**ADC Planning Consultation
Response from the Historic Buildings Adviser**

Application Number	FP/143/13/
Address	Church House, 94 Felpham Road, Felpham, PO22 7PG
Description	Application for for the change of use from office (B1 Business) to residential use (C3 Dwelling House).
Case Officer	Simon Davis
Site Visit	18 September 2013

BLOCK PLAN
Scale 1:500

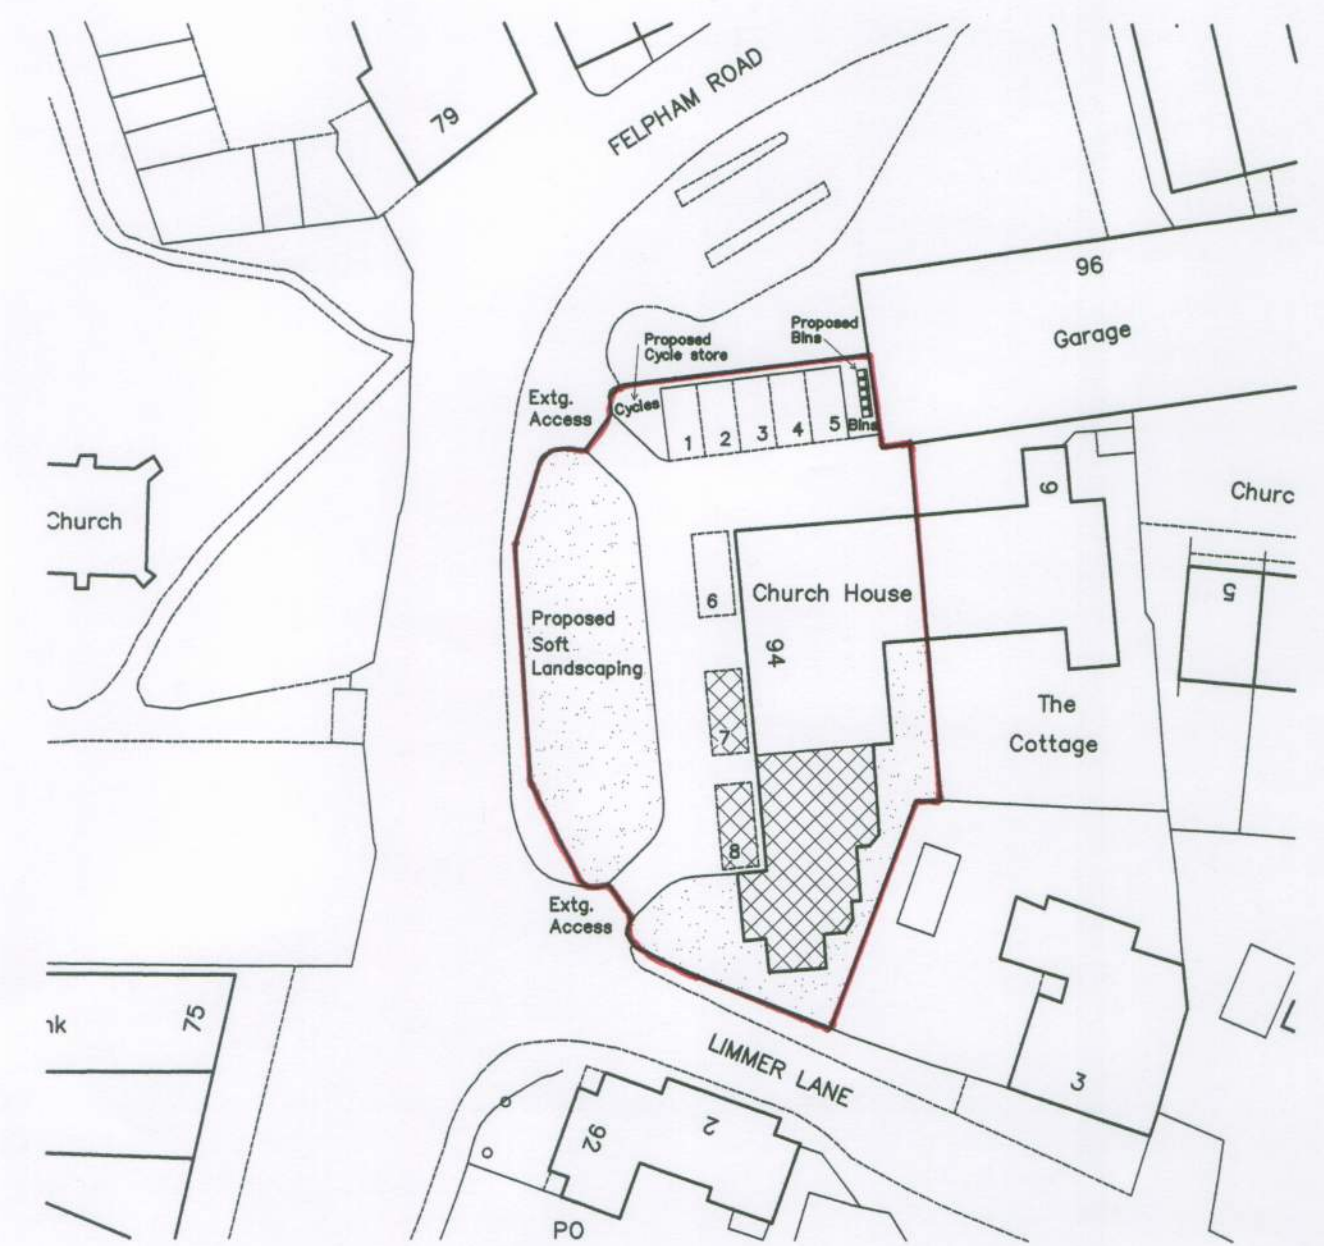
Whilst the principle of a dwelling here is not particularly problematic, there are concerns with the future proposal to 'hard landscape' the front of the building. The use of tarmac would not be acceptable here, nor would the strong demarcation of parking bays, ie through painted lines. These material alterations would significantly harm the setting of the listed building and in turn the quality of the Conservation Area, which is not acceptable.

Therefore, if the proposal is reliant on this type of treatment, it should be resisted for the reasons above. However, if the scheme can be implemented maintaining a soft landscape appearance, such as with gravel, then the scheme can be recommended for support.
